Application for a Non-Material Amendment Following a Grant of Planning Permission

Renovation of Coach House to provide community foodbank space.

PA23/04718

2269 Design Statement 2
2269-301-Rev(PS2) Proposed

North Elevation
1 : 100

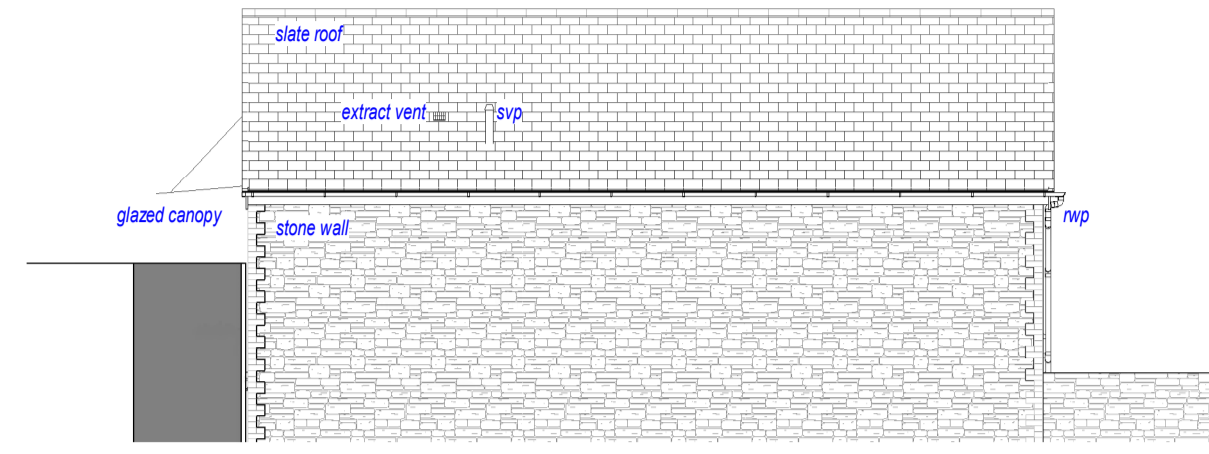
- north elevation glazing frame material not necessarily powder coated aluminium
- glazed canopy over main entrance to satisfy Building Regulations
- north elevation signage moved to allow for glazed canopy
- bollards outside the main entrance to satisfy Building Regulations
